CITY OF ALBUQUERQUE

RE: Desert Ridge Place Unit 3
Grading and Drainage Plan
Engineer's Stamp Date 2-14-2017 (File: C20D076)

Based upon the information provided in your submittal received 2-15-2017, the above referenced Grading and Drainage Plan is approved for preliminary plat and grading permit with the following condition:

TITLE: DESERT RIDGE PLACE UNIT 3 GRADING AND DRAINAGE PLAN
DESIGN REVIEW COMMITTEE: CITY ENGINEER APPROVAL
LAST DESIGN UPDATE: MO./DAY/YR. MO./DAY/YR.
CITY PROJECT NO. ZONE MAP NO. C-20-Z SHEET 1 OF 1
DESIGNED BY DLH DATE 01/17
DRAWN BY DER DATE 01/17
CHECKED BY DMG DATE 01/17

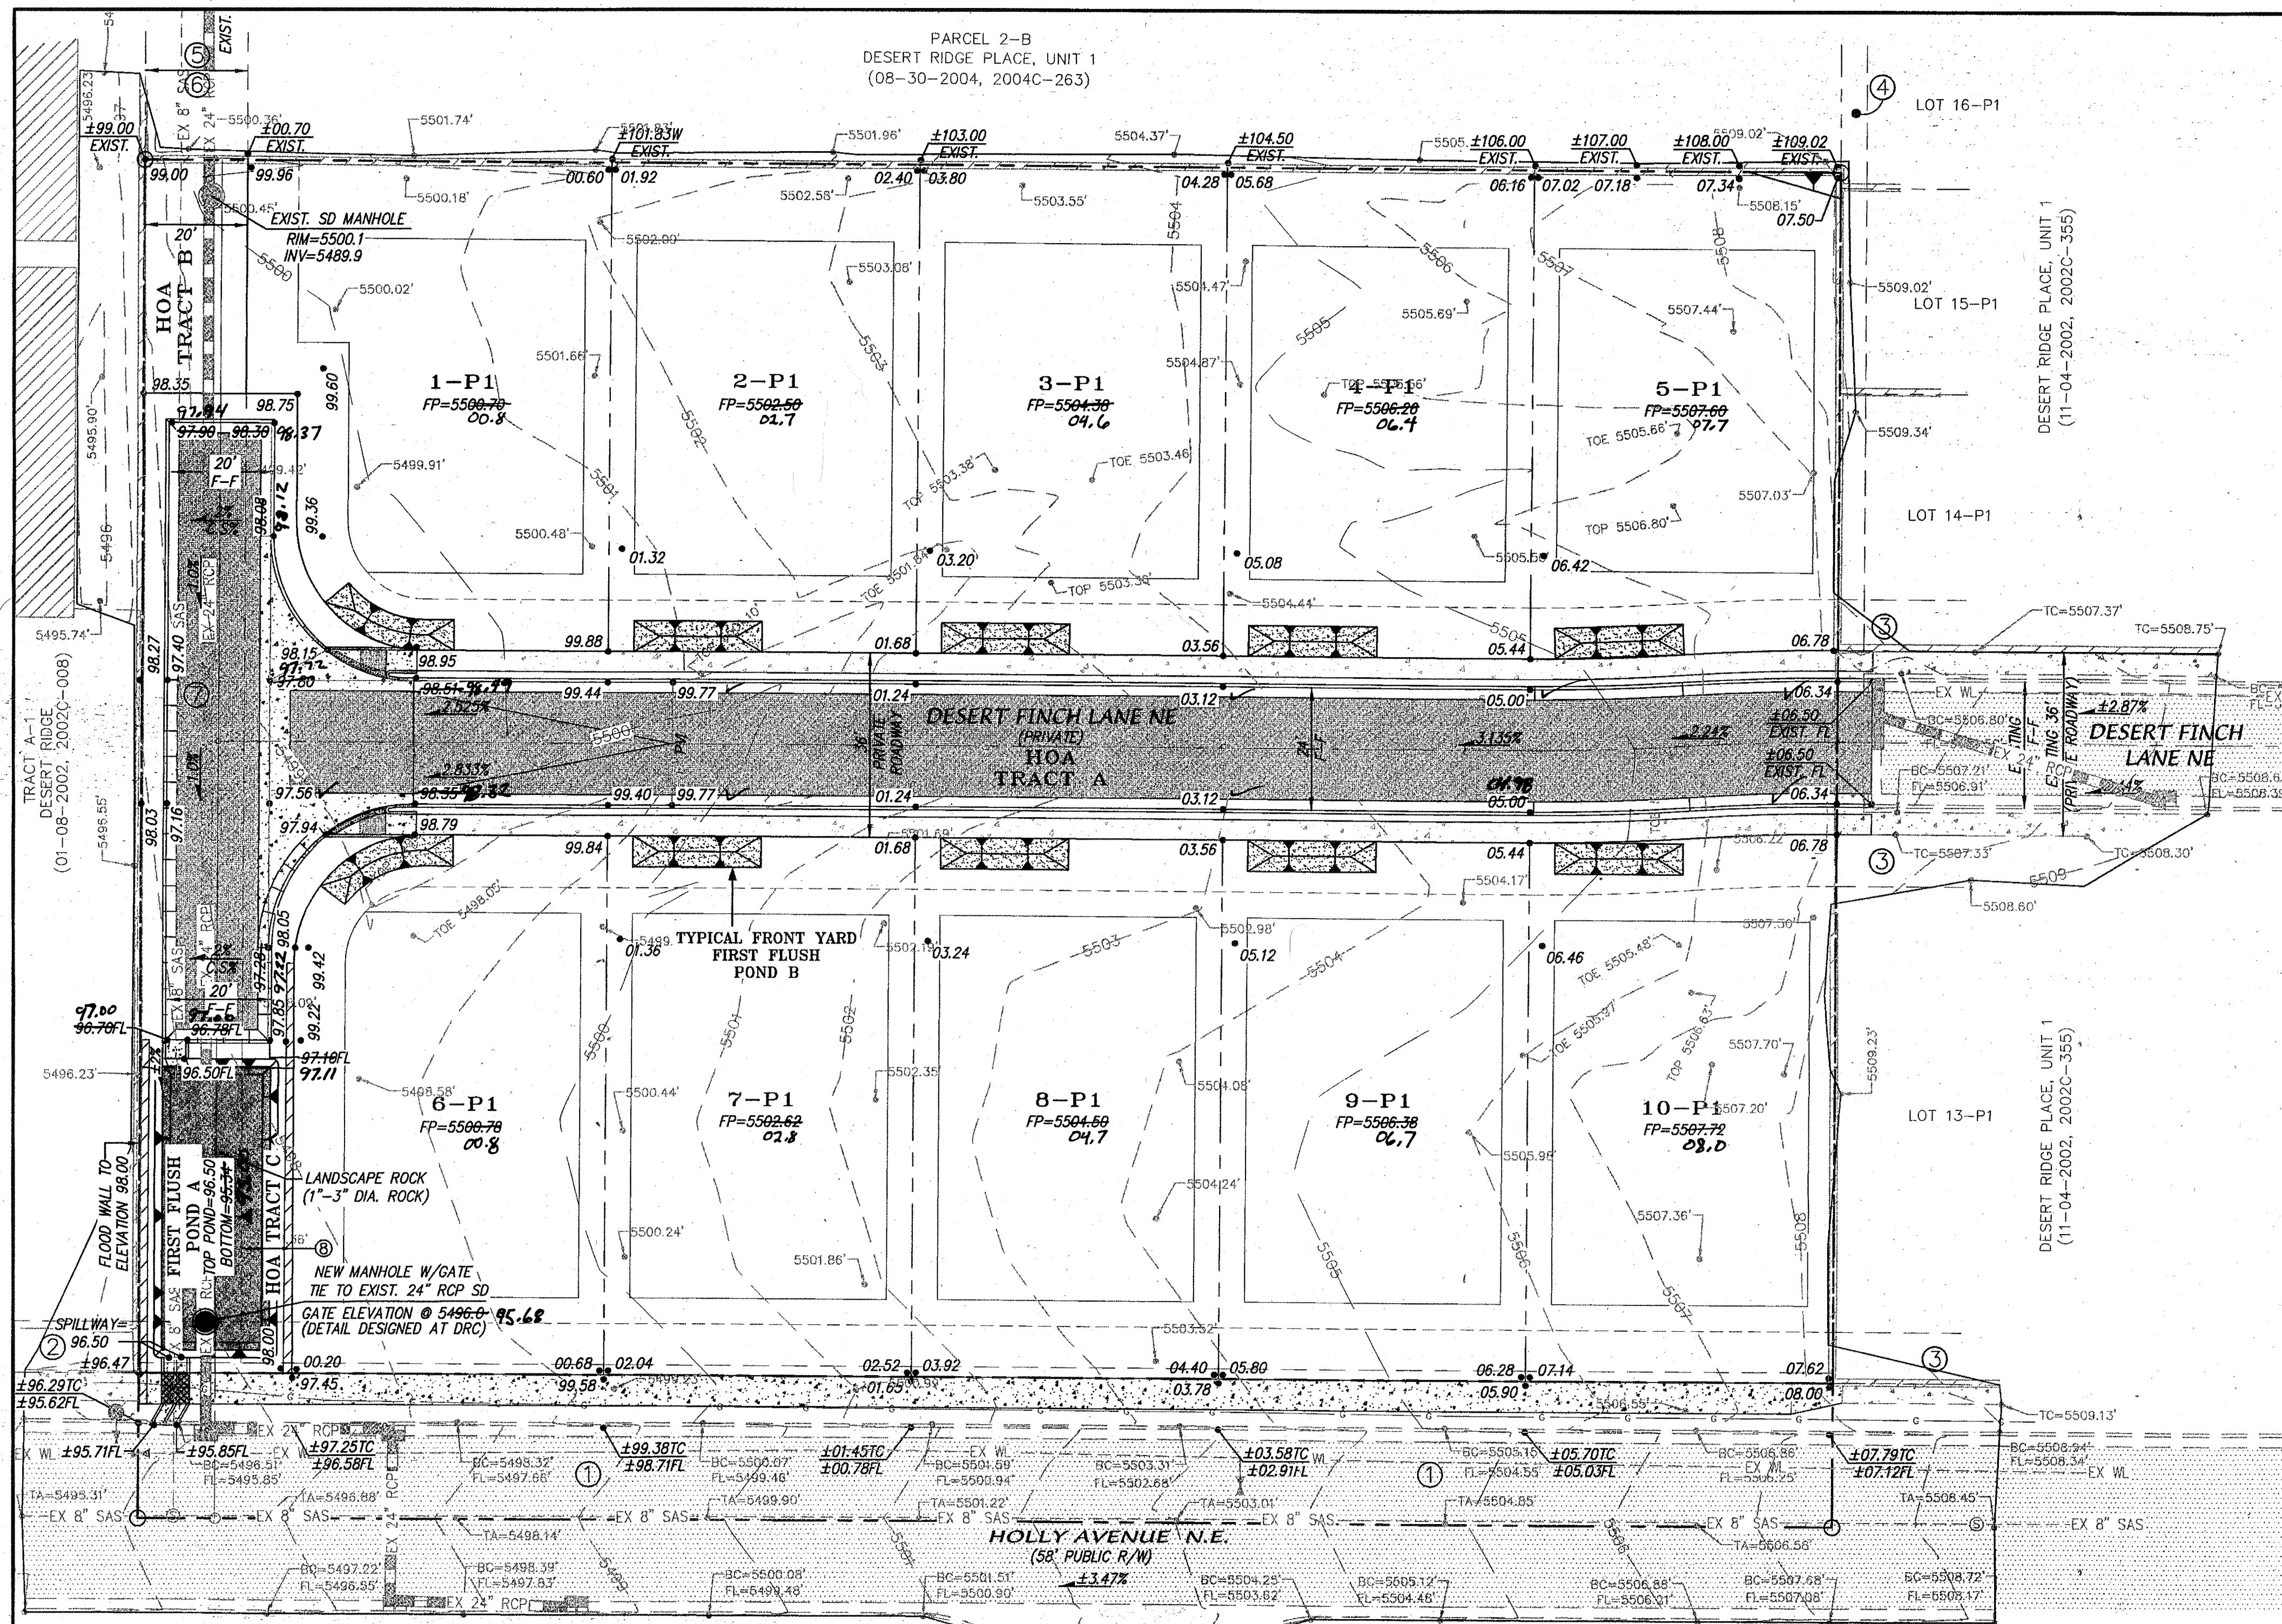
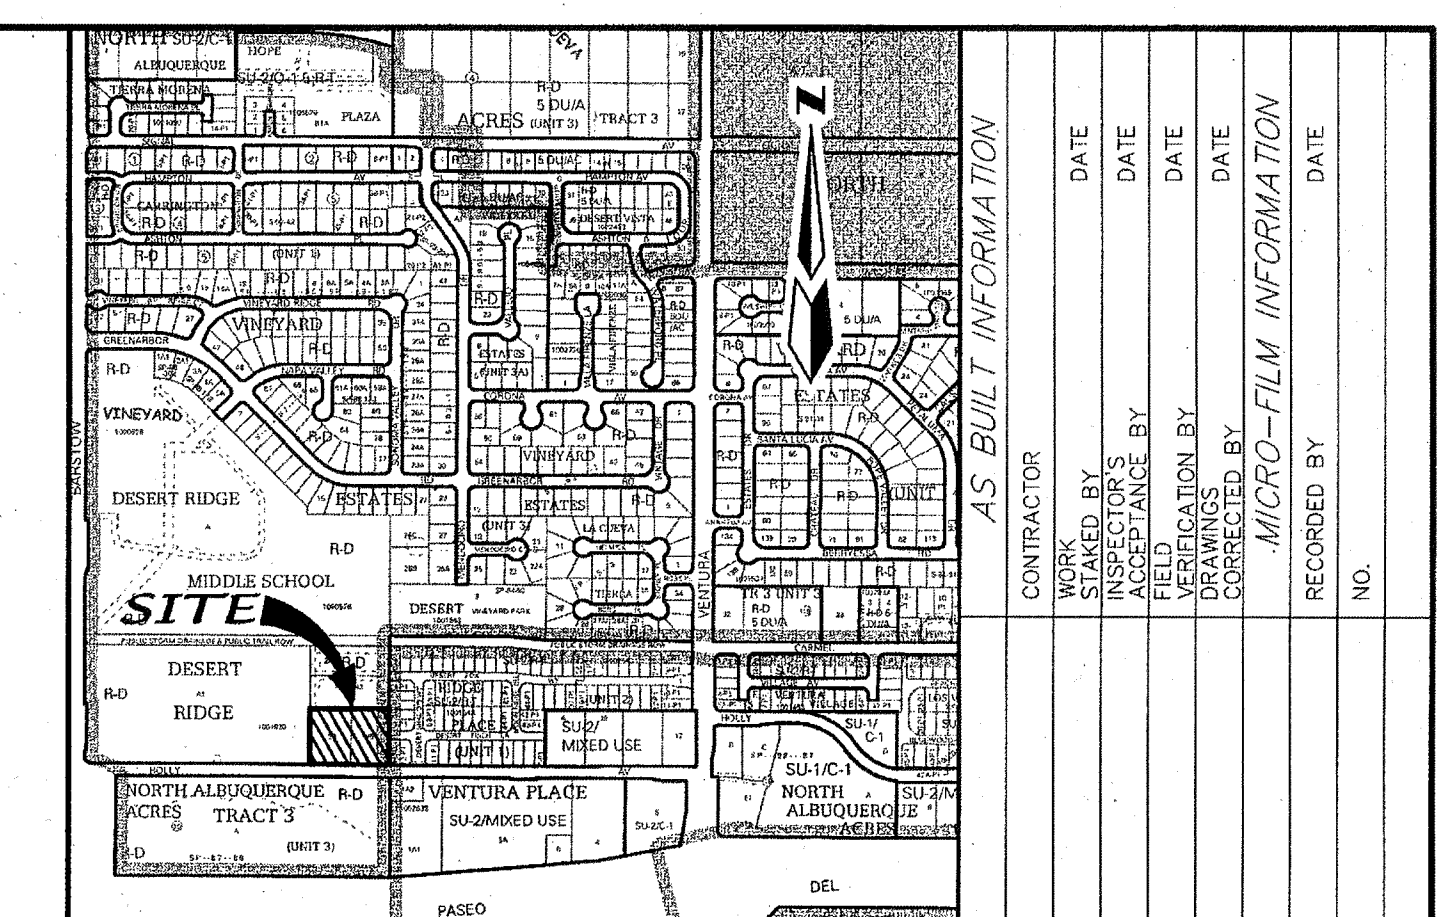
Sidewalk culvert must extend from face of curb to the property line (wall).
